Judge Orr Ranchettes, SF-17-021

Please accept the following comments from El Paso County Public Health (EPCPH) regarding the 40.67 acre, 7 residential lot development project referenced above:

JUDGE ORR RANCHETTES

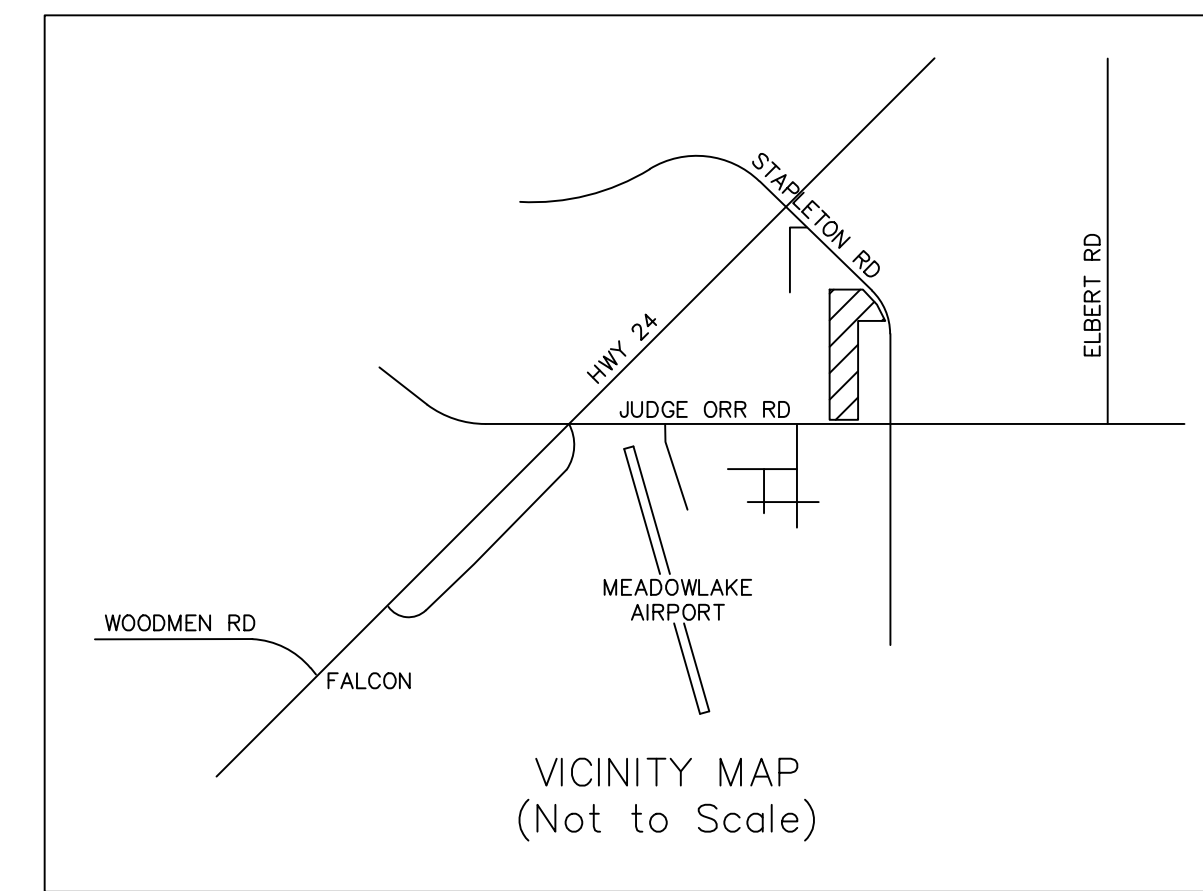
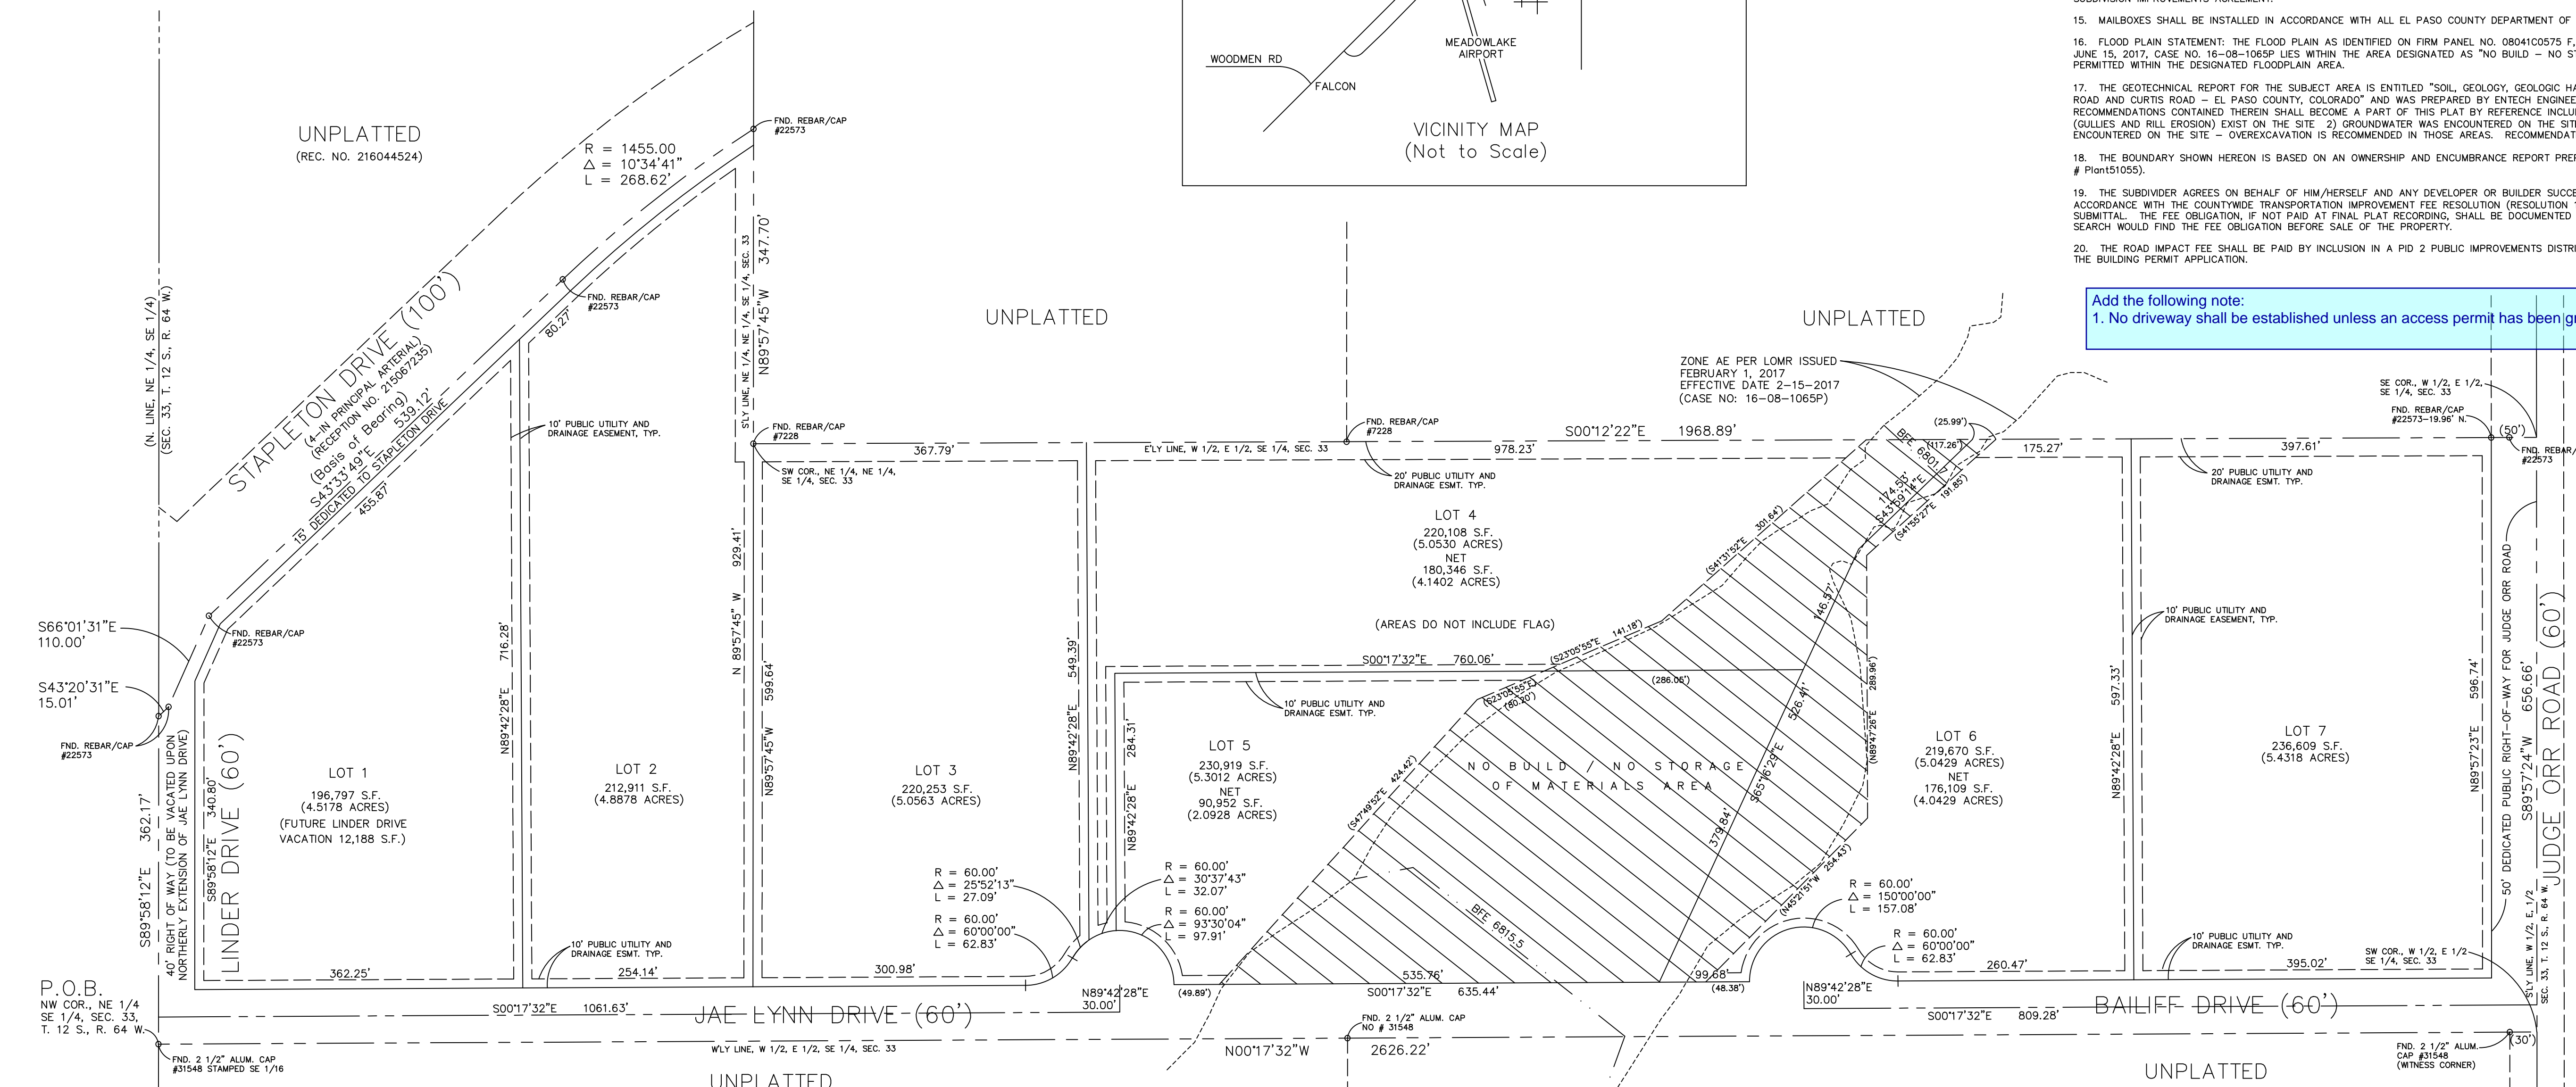
- **Careful planning is required when locating private wells and OWTS's on lots 5 and 4 because of the flood plain (no-build area) impact on lot 5 and the narrow shape of adjoining lot 4.**
